THE NEW SYDNEY FISH MARKET AT BLACKWATTLE BAY MAIN WORKS DEVELOPMENT APPLICATION RESPONSE TO SUBMISSIONS

Infrastructure NSW

BBC Consulting Planners

February 2020

3 ROOF PLAN
1:50

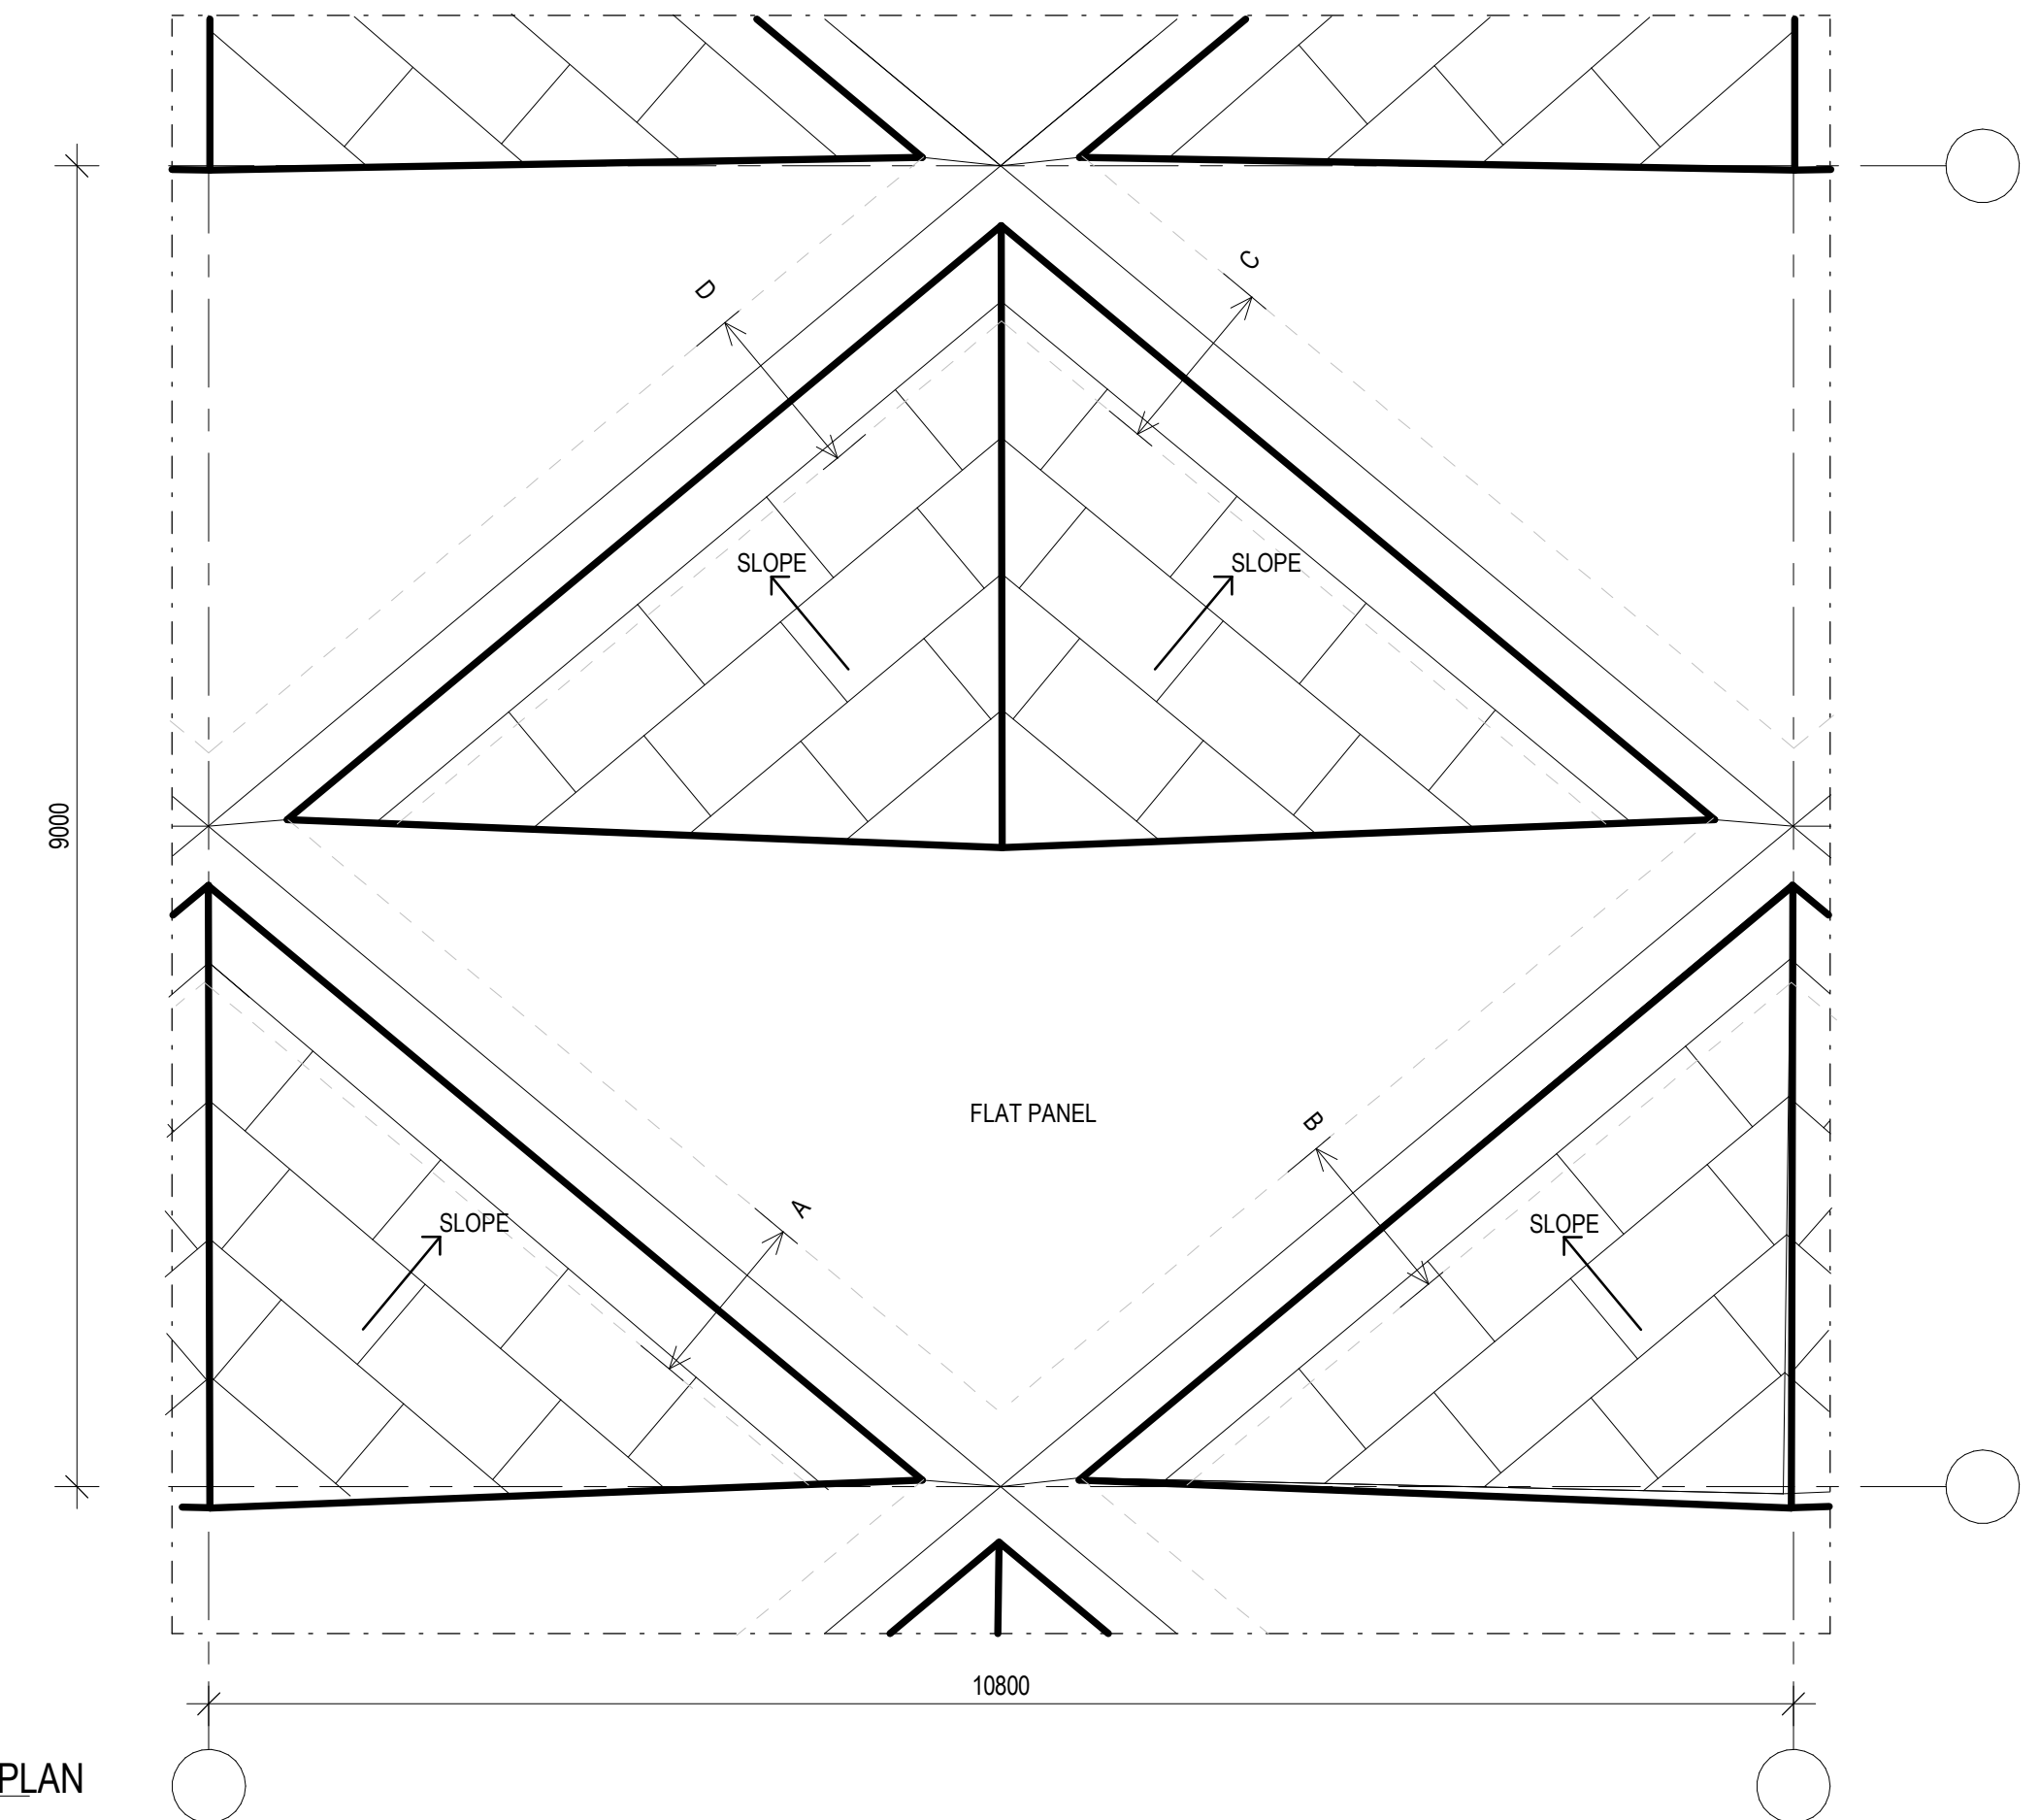
- *Clarify the commitment to use the roof structure for solar power generation, noting 'consideration' is given to solar roof cells meeting 5% of electricity load in the Ecologically Sustainable Development report.*

The NSW Government has approached the new Sydney Fish Market project with the specific goal of pushing the boundaries of ecological sustainability by targeting world class initiatives. The development is committed to achieving a 5 Star Green Star rating and is targeting a 6 Star Green Star rating. Among the range of measures that are planned to be implemented to meet the committed 5 Star rating is a 335kW solar system using integrated photovoltaic cells (PV) on the roof of the building. This is equivalent to 67 average residential PV systems (5kW).

Figure 8 Vehicle / cyclist conflicts with dedicated cycleway on Bridge Road

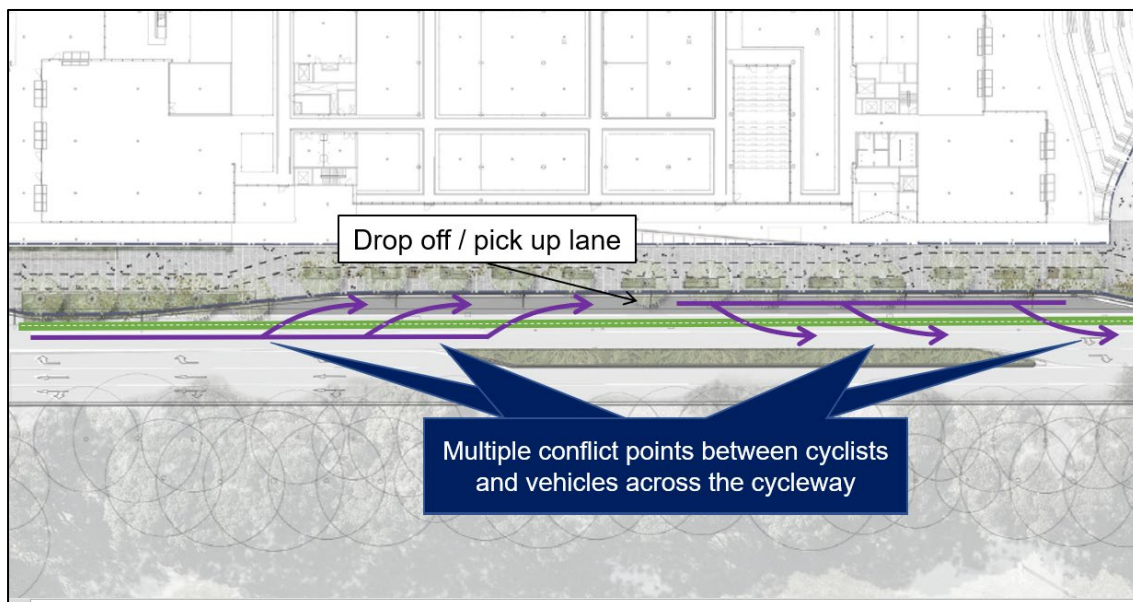
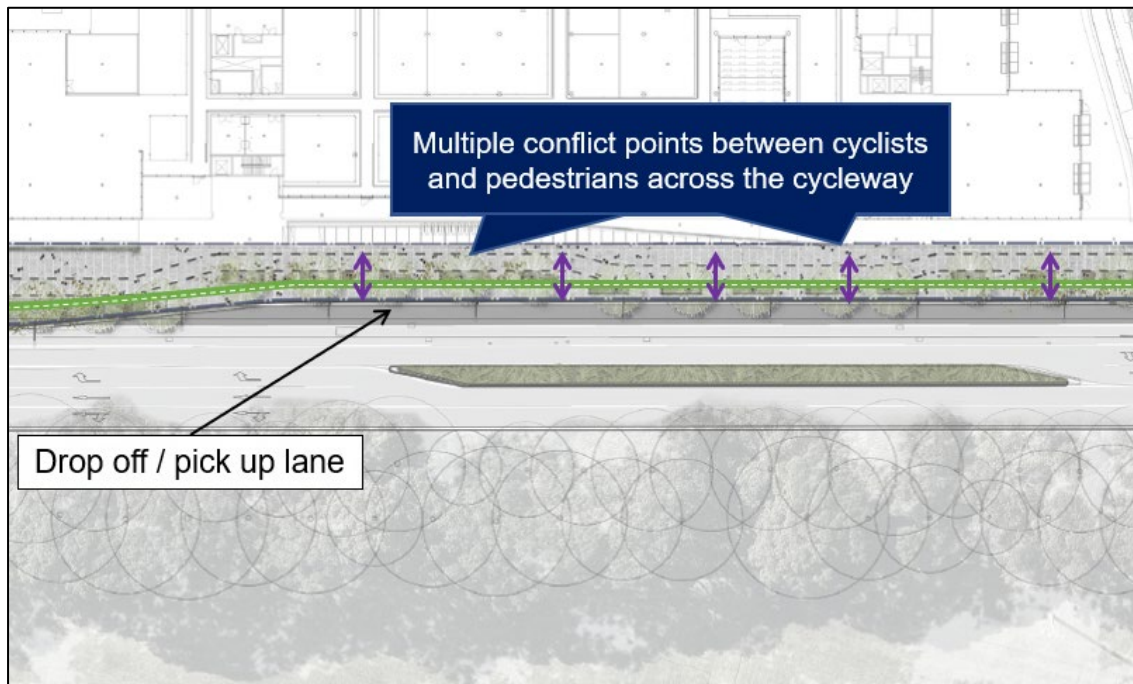
| Agency | Matter Raised | Submission | Response |
|--------|----------------------------------|--|---|
| | Traffic - provision for bicycles | <p>A new dedicated off-road cycling connection along Bridge Road adjacent to the frontage of the site is identified in the Transport Impact Assessment. However, details on the cycling connection and integration with the surrounding cycle network are not provided.</p> <p>It is requested that the applicant:</p> <ul style="list-style-type: none"> • Investigates providing new off-road cycling connection on Bridge Road in accordance with the relevant Austroads cycling standards; | <p>The issue of shared path for bicycles is addressed in detail in Section 2.5 of the supplementary transport report (Appendix 8). Alternatives have been considered and the proposed shared path is considered the most suitable.</p> |
